Application No: EP/55/22/PL
Site Address: 4 Beechlands Cottages Beechlands Close East Preston BN16 1JT
Description of works: Variation of condition imposed under EP/41/17/PL relating to condition 2-approved plans.

Thank you for your internet representation made on 21st June 2022 which has been recorded as an objection with the comments as follows:

East Elevation

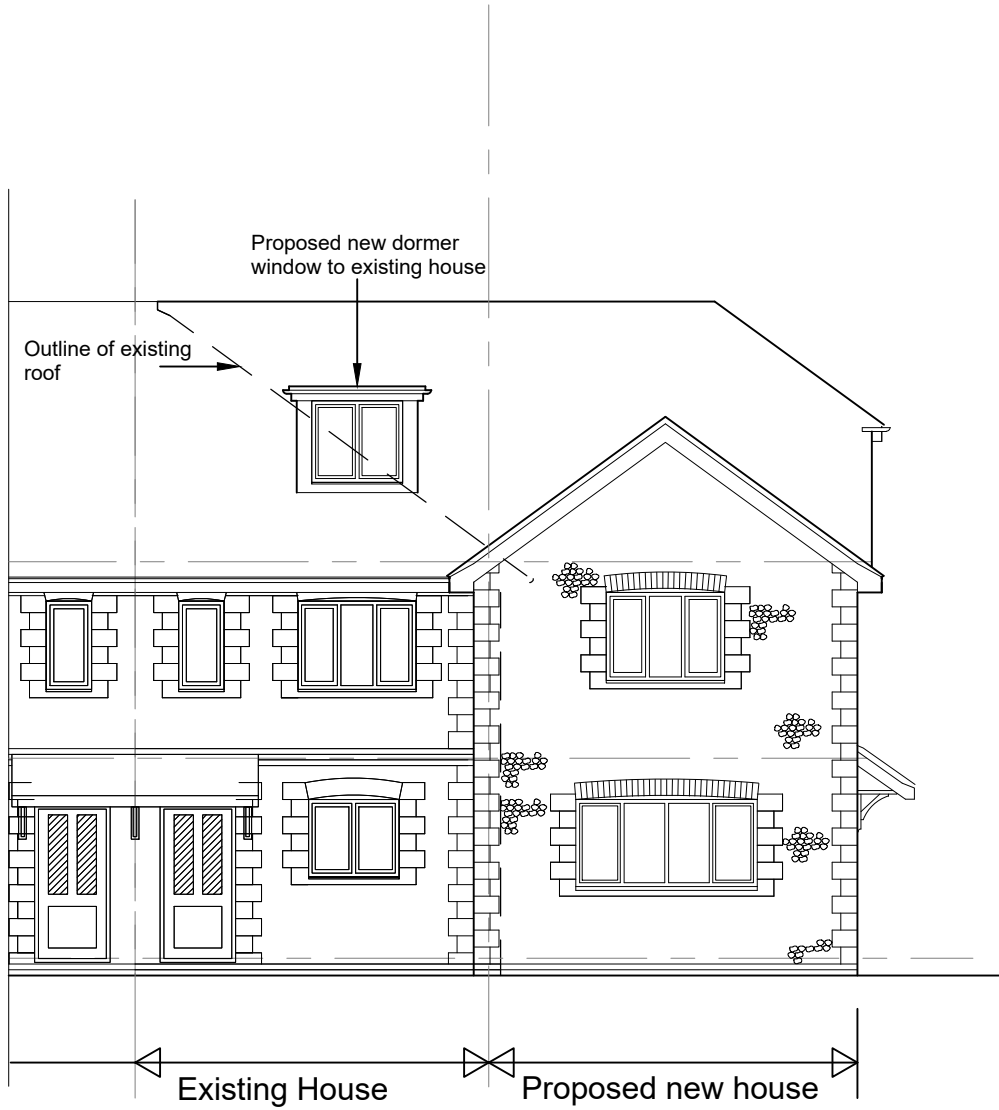
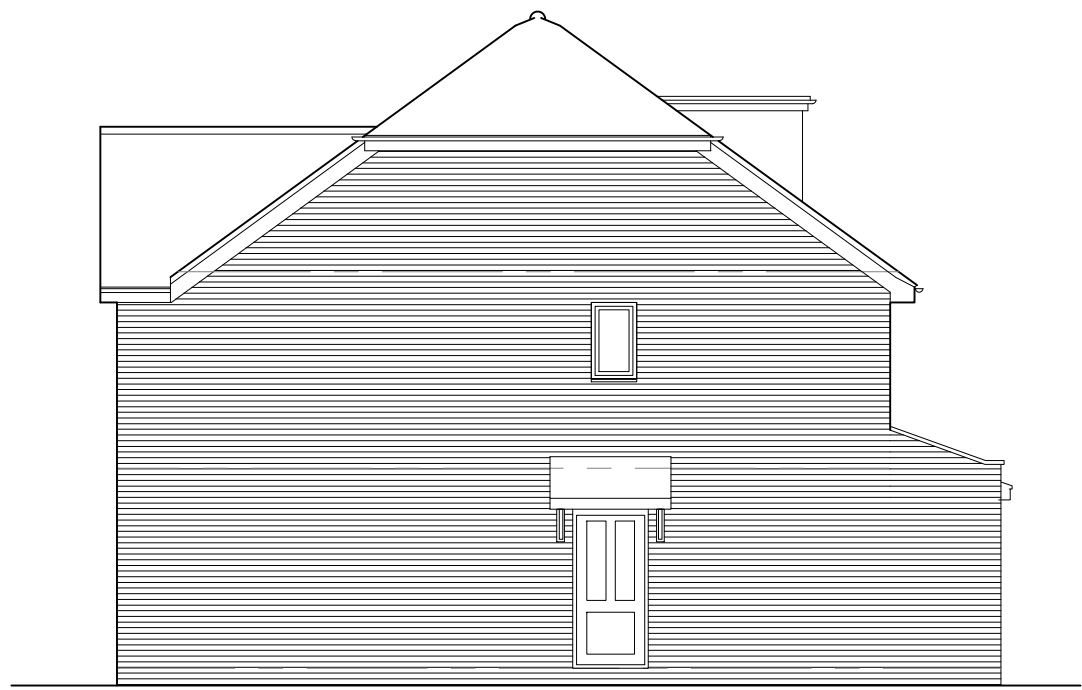
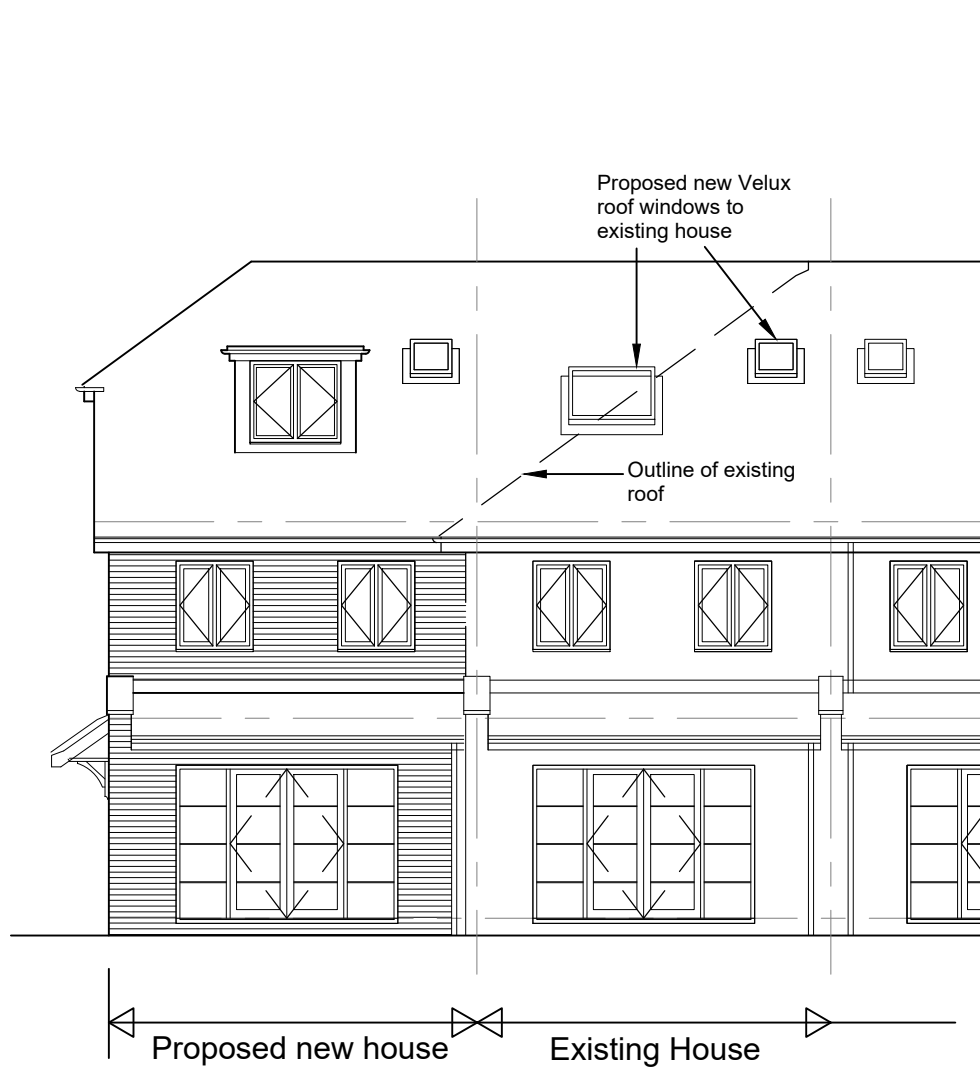
This council's Planning & Licensing Committee considered this Application at its meeting on 13th June. The committee agreed it would raise the same objections as it had to EP/41/17/PL, with additional concerns about the lack of amenity space provided, the safety of the east-facing front door opening on to a driveway to the rear of the site, and concerns about parking provision.
